**Application by AQUIND Limited for an Order Granting Development Consent for the AQUIND
Interconnector Project**

Response to Deadline 7 Submissions on behalf of

CPRE HAMPSHIRE

(Reference 20024996)

wsp AQUIND
AQUIND Interconnector
Additional Viewpoint 1b:
Baseline Winter
Figure 15.59C

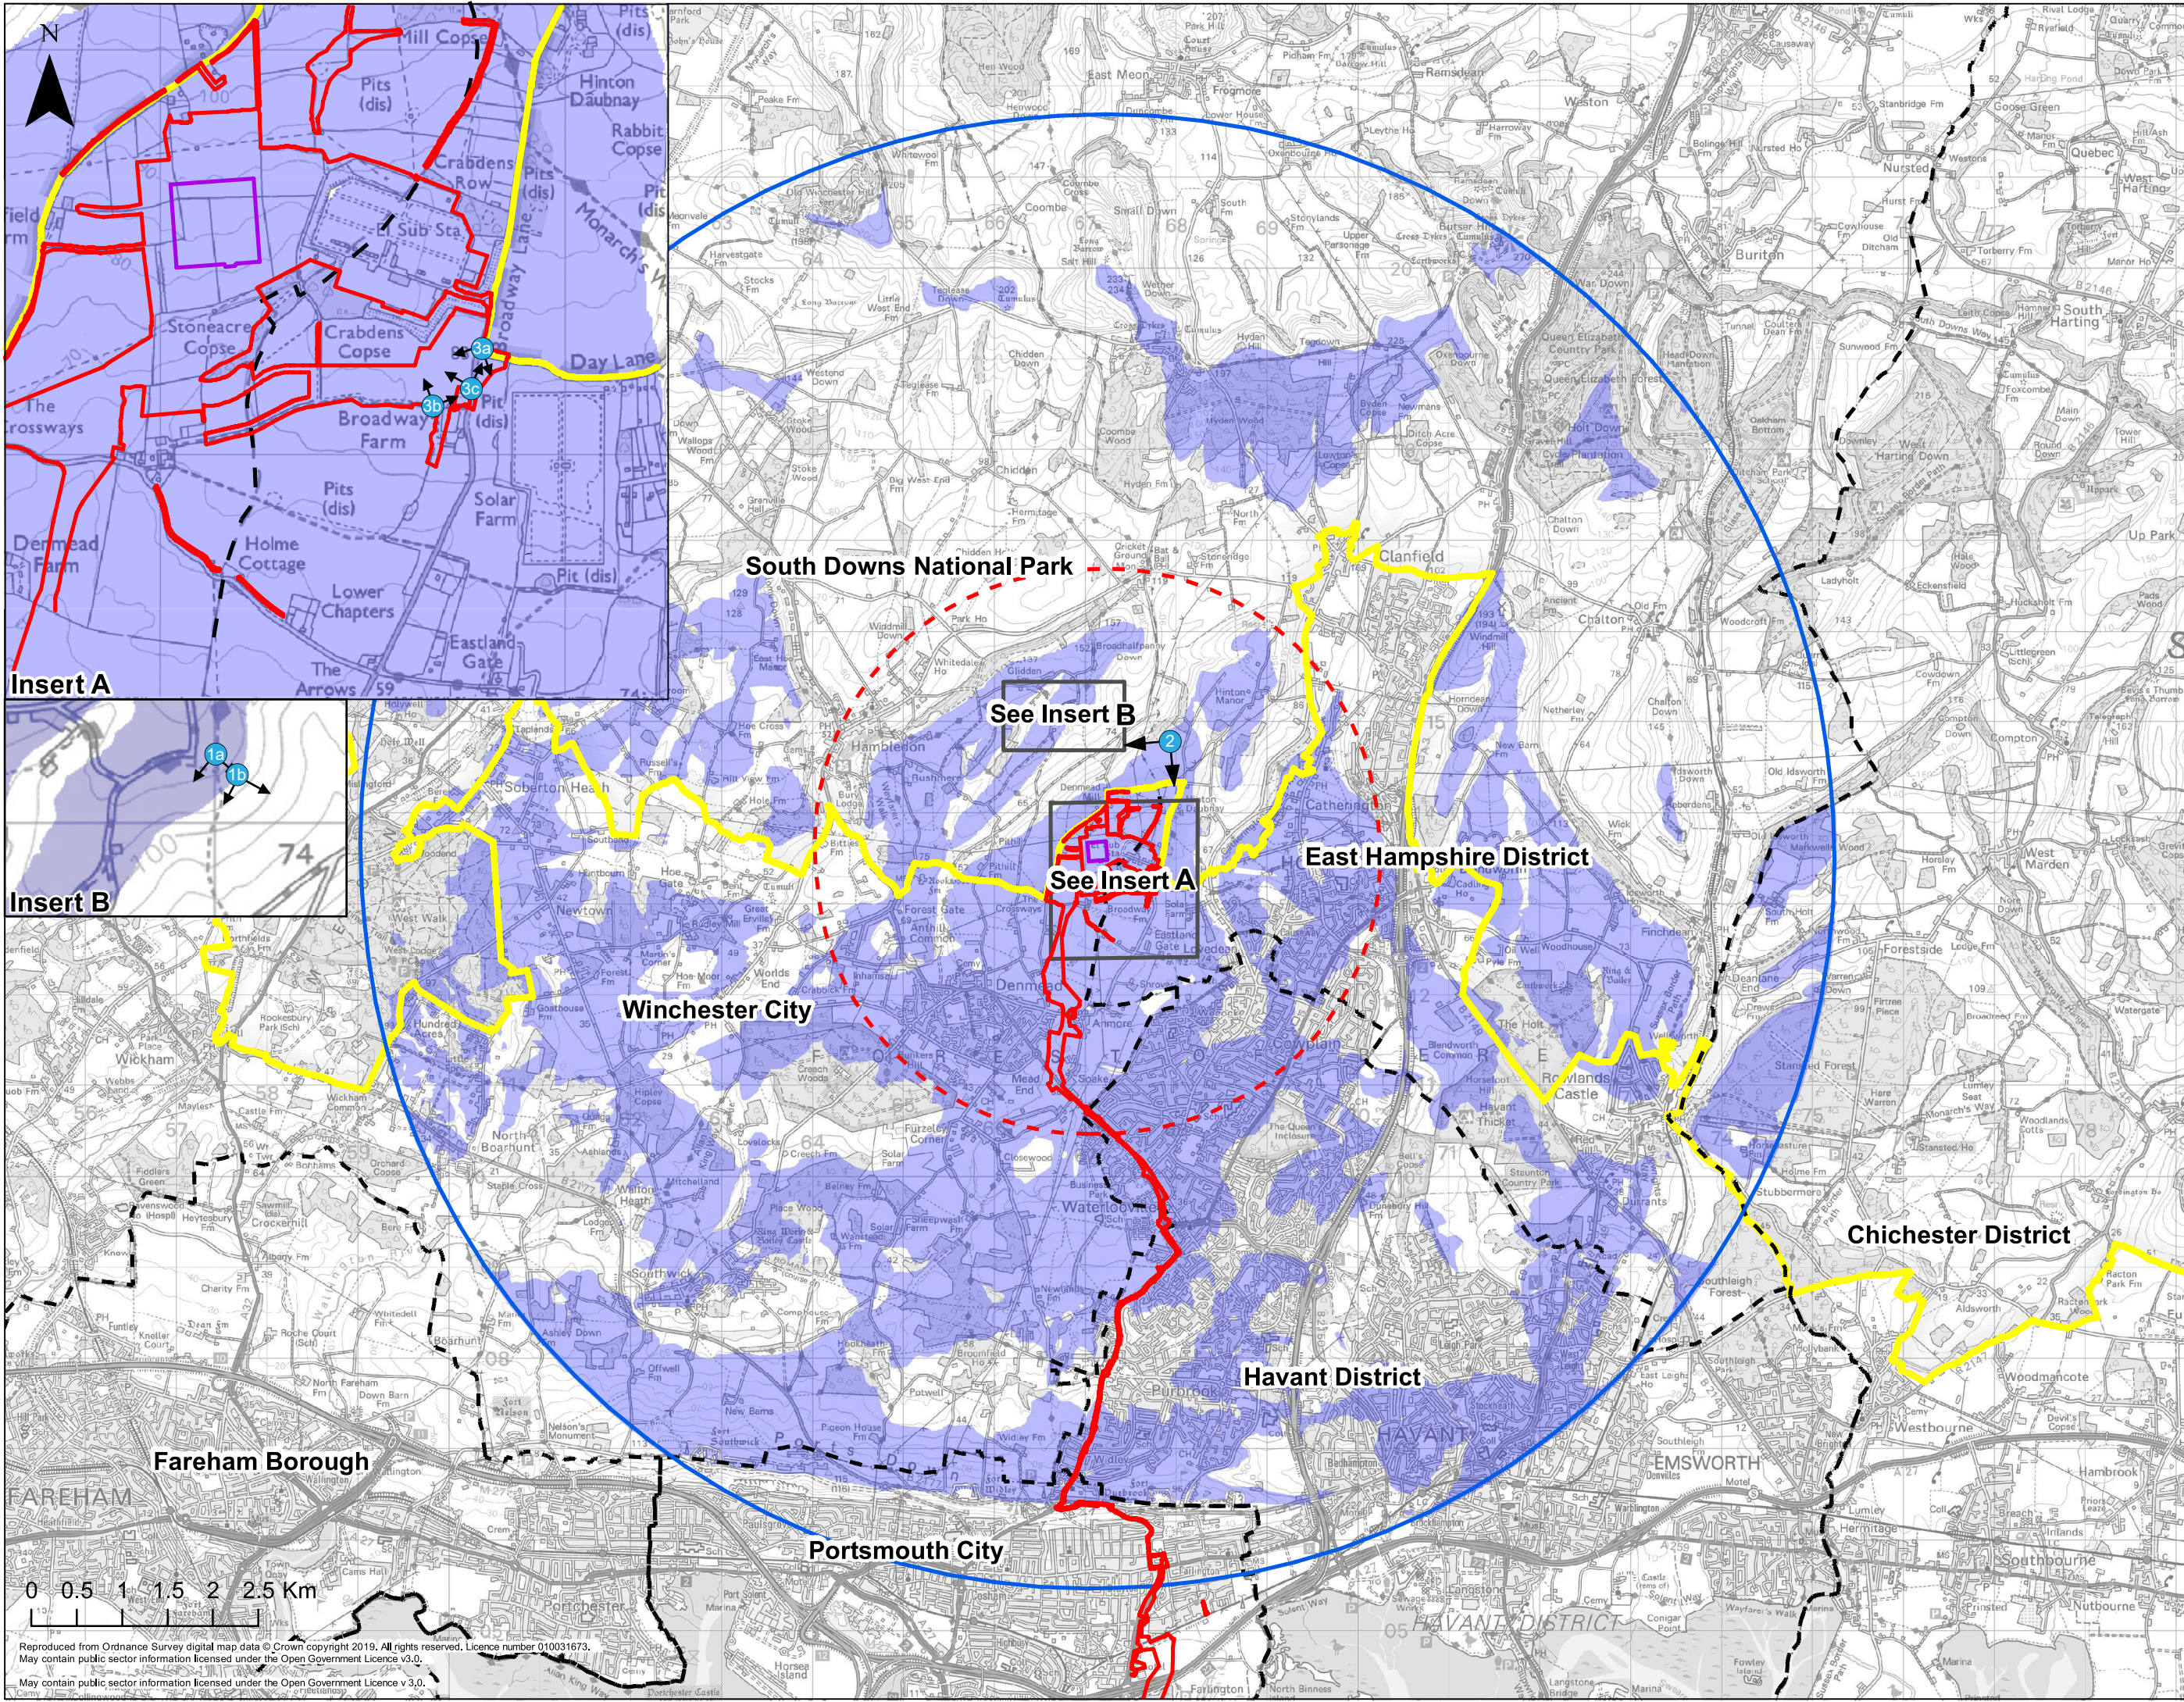
Due to Covid restrictions, we have not had an opportunity to see for ourselves the view towards the converter station from new Viewpoint 2, a footpath at Prew's Hanger within the SDNP, but note that the effect on visual amenity of the converter halls is assessed by the Applicant as Significant at Year 0 and Year 10, taking account of anticipated ash dieback. This footpath is an interconnecting route which is valued and well used by the public. This Significant Adverse Effect would be additional to those identified in the Environmental Statement.

Drawing file: EN020022 / EN020022-003555-6.2.15.49 ES - Vol 2 - Figure 15.49 - Indicative Landscape Mitigation Plan Option B(i) (south) Rev04.pdf

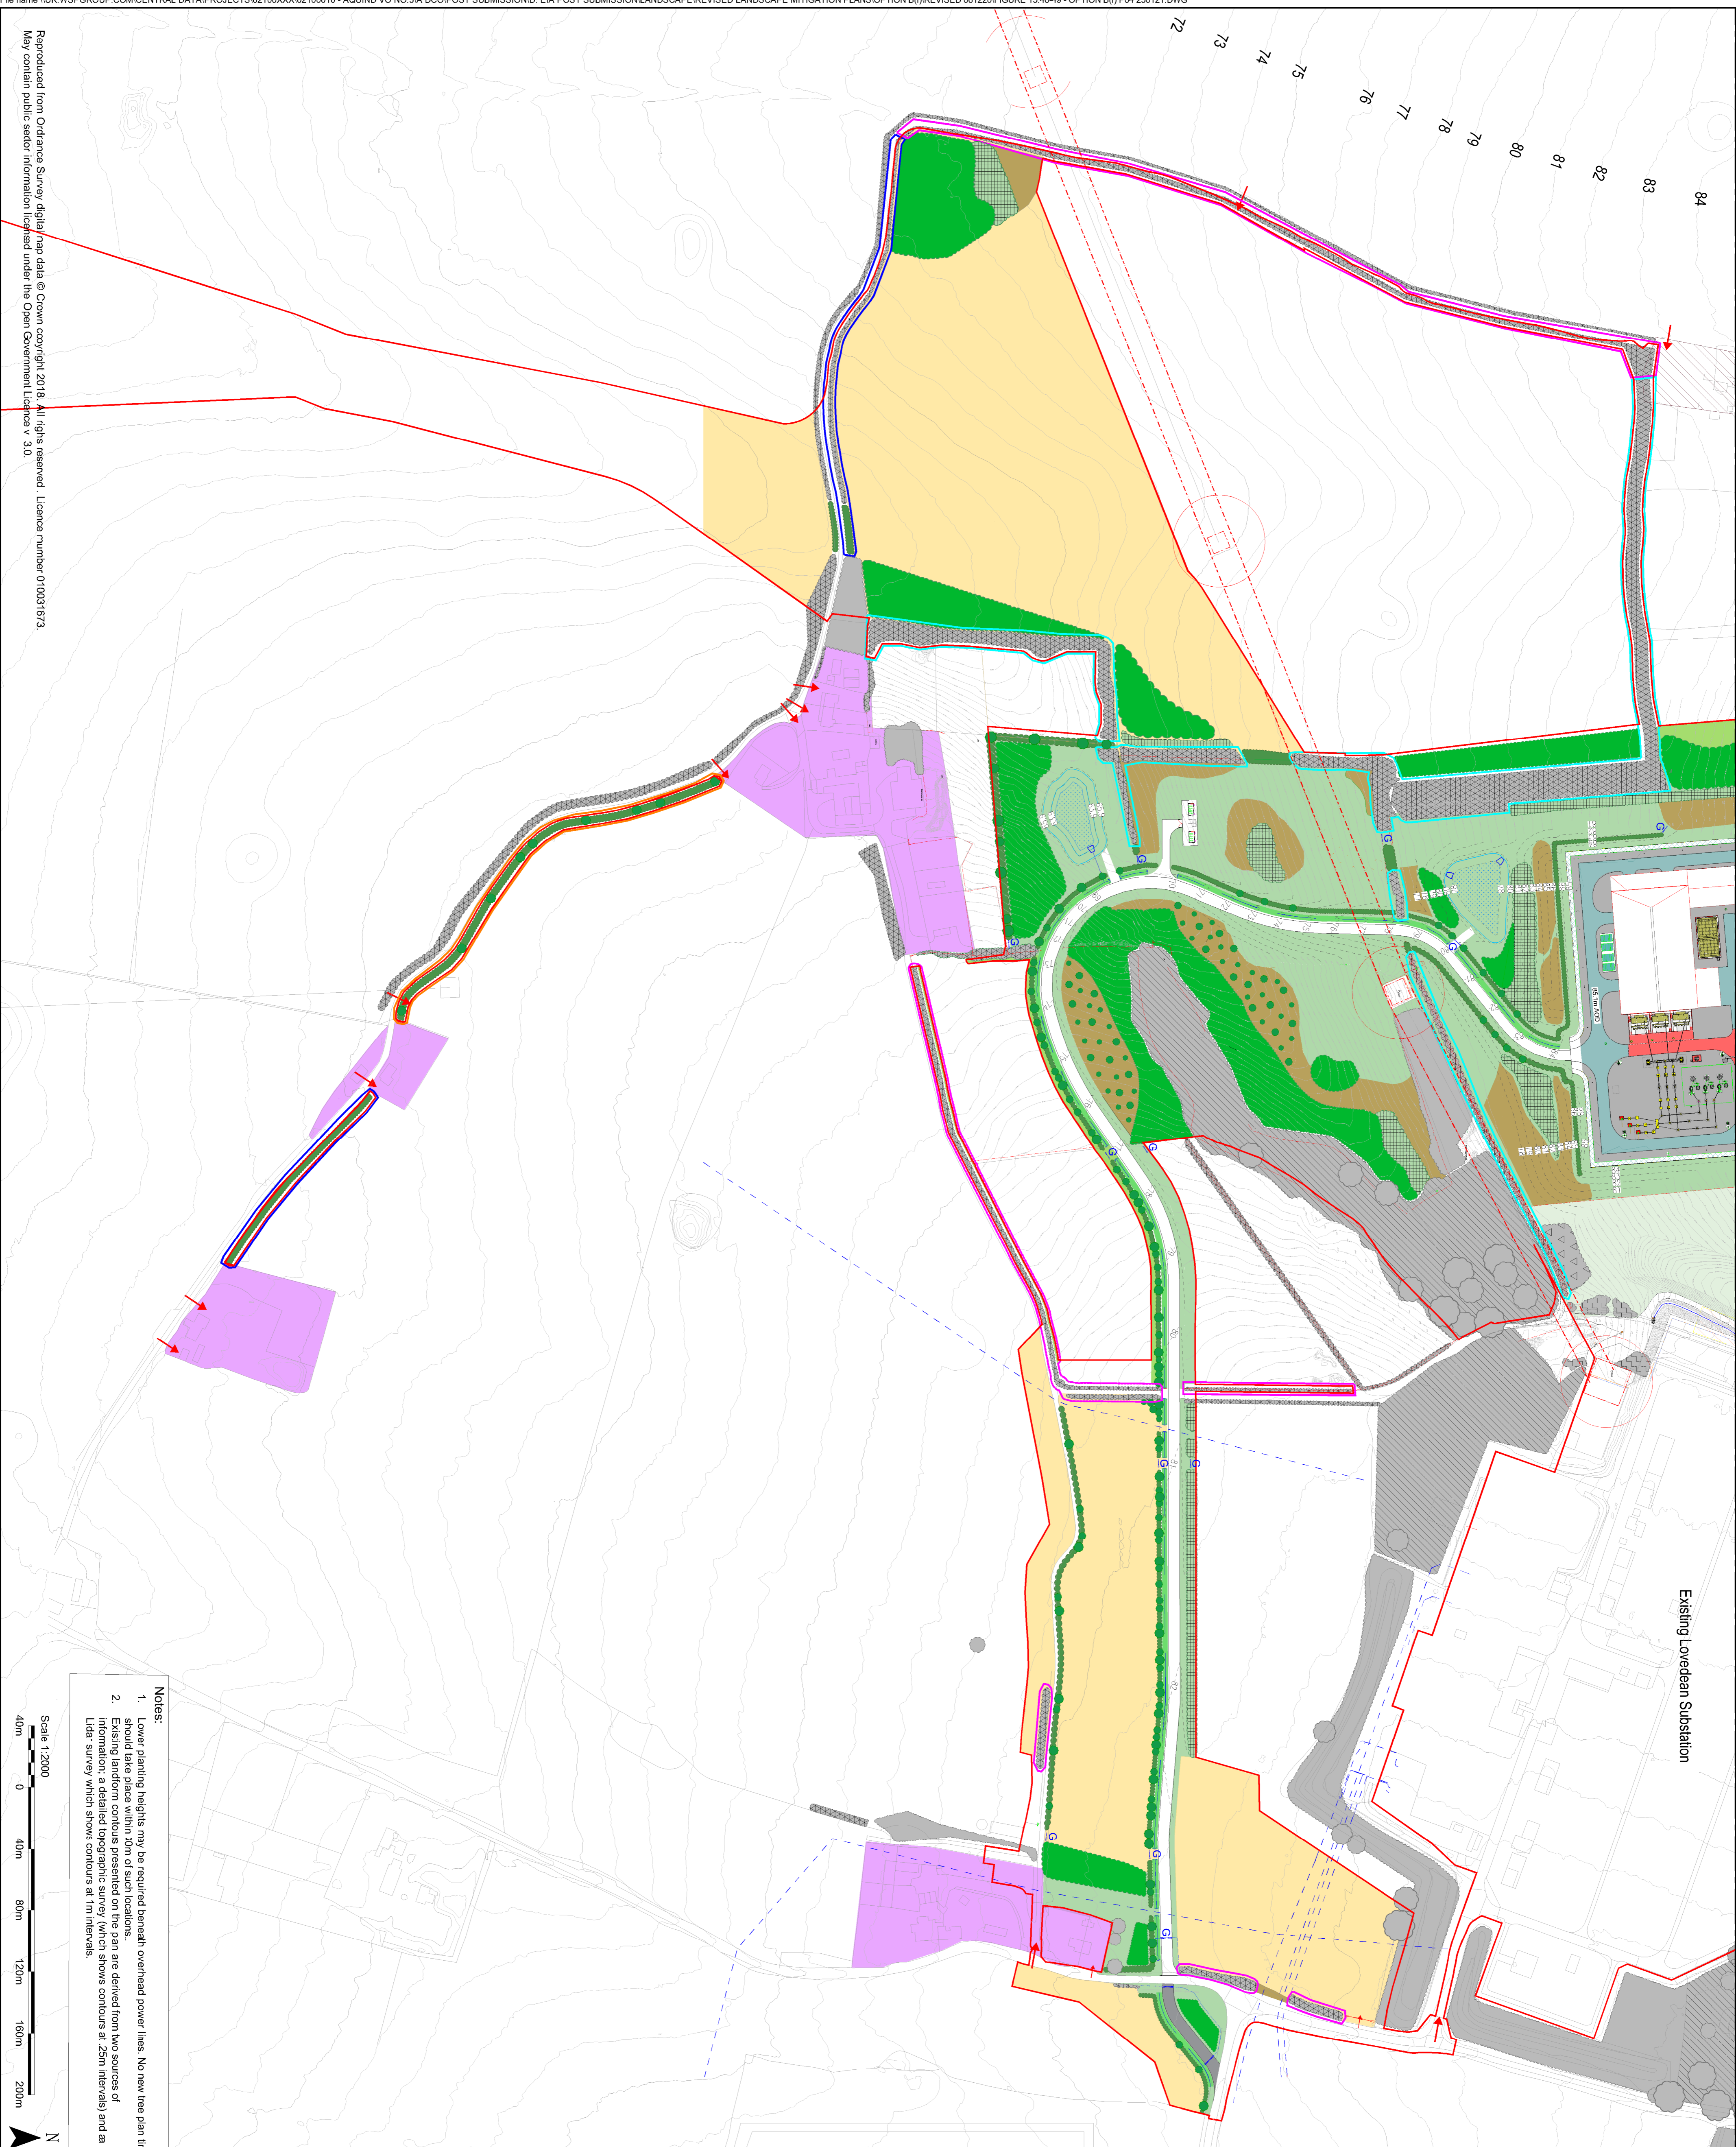
As regards exact location of the converter halls, should a DCO be granted, CPREH strongly supports Option B(ii), which would assist landscape mitigation by retention of an important north south hedgerow with trees.

However, of particular concern, is the advent of ash dieback which it is agreed would reduce the mitigating effect of existing vegetation on the Significant Adverse Effects of the converter halls on landscape character and visual amenity as time goes on. So, we strongly support the bringing of Mills Copse and Stoneham Copse within Order Limits so that they can be managed to limit the impact of ash dieback. However, where consisting of ancient woodland management would be needed to maintain and enhance habitat value. Use of a Deed of Grant of Easement is considered appropriate to secure management of landscape features which contribute to screening of the converter halls but are not owned by the Applicant.

Nevertheless, the change to the future baseline which results from ash dieback only reinforces our concern expressed in the CPRE Representation as to the limited extent to which maturity of the mitigation planting after 20 years would reduce the Significant Adverse Effects of the converter halls on landscape character and visual amenity. Significant increased effects at Year 0 and Year 10 on some recreational users following ash dieback, including the Monarch's Way, are acknowledged by the Applicant. So, CPRE Hampshire continues to maintain that the landscape and visual effects of the converter halls need to be judged solely on the assessment at Year 0, as ash dieback would likely reduce the screening effect of planting for much of their 40 year life.
